WELWYN HATFIELD COUNCIL – DEVELOPMENT CONTROL
WORKS TO TPO TREES DELEGATED REPORT

APPLICATION No:	<u>S6/2014/0134/TP</u>
------------------------	-------------------------------

Reduce 10 trees (9 hornbeam and 1 ash) to 11m in height due to alleged effect on garage.

Heave / settlement damage  
Tree survey

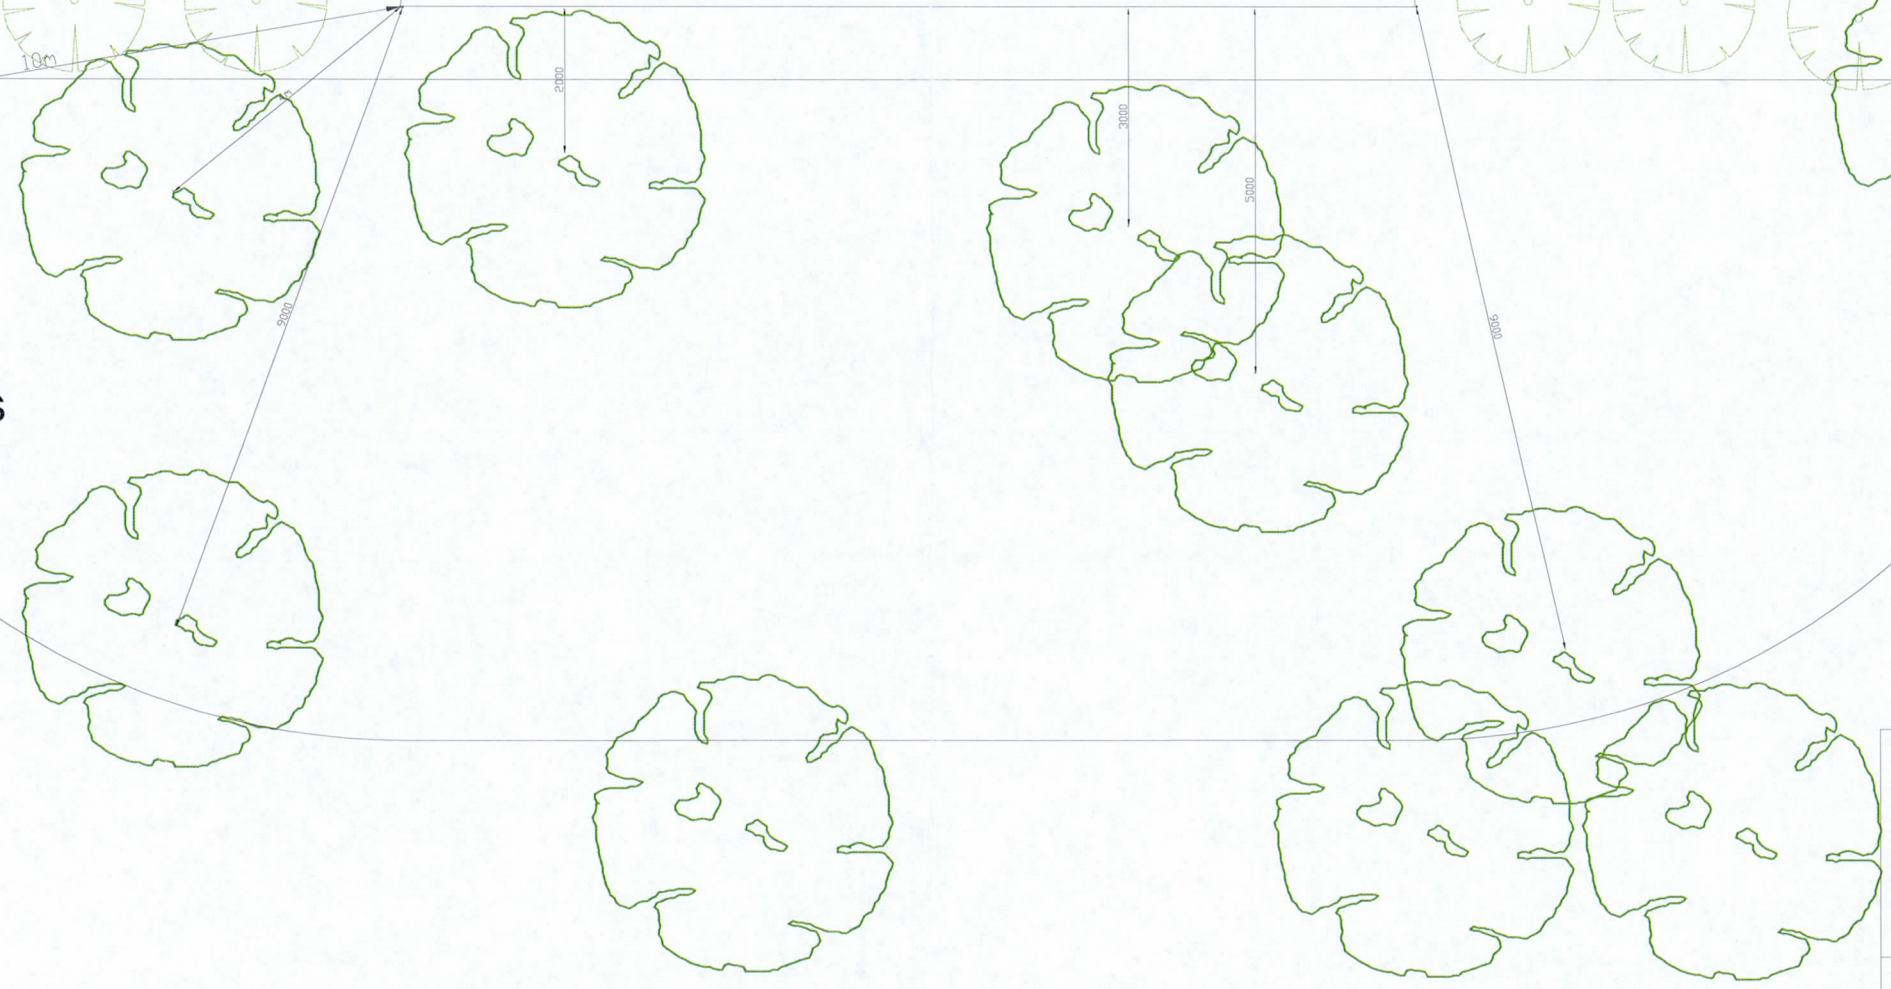
The proposal is to top the trees to 11m in height due to movement in an adjacent freestanding garage. A survey (by T Dawson, undated but with accompanying drawing dated January 2014) has been included in the application. The survey includes no details relating to; the plasticity of the soil; the soil-moisture deficit; the foundations on this relatively new building; or seasonal variation in the widths of the cracks. Although the report notes the large Leyland cypress hedge running along the boundary it makes no discussion about this. Overall, the survey has insufficient information to link cracking in the building with the adjacent trees.

risk of the tree falling onto the road. Of the hornbeams; 2 have been previously cut to this height before; 2 are only a little taller than 11m in height; and 3 are drawn up due to the surrounding trees with little side branching. The affect on the amenity of these trees will be limited. The works are going to have most amenity impact on only 1 hornbeam tree, sited adjacent to the road and with a slightly broader crown. This tree appears to have reasonable vitality and is unlikely to be detrimentally affected by the works.

2. The works shall not be started and completed other than in accordance with the approved plans and details: tree(s) location plan received and dated 28 January 2014 unless otherwise agreed in writing by the Local Planning Authority.
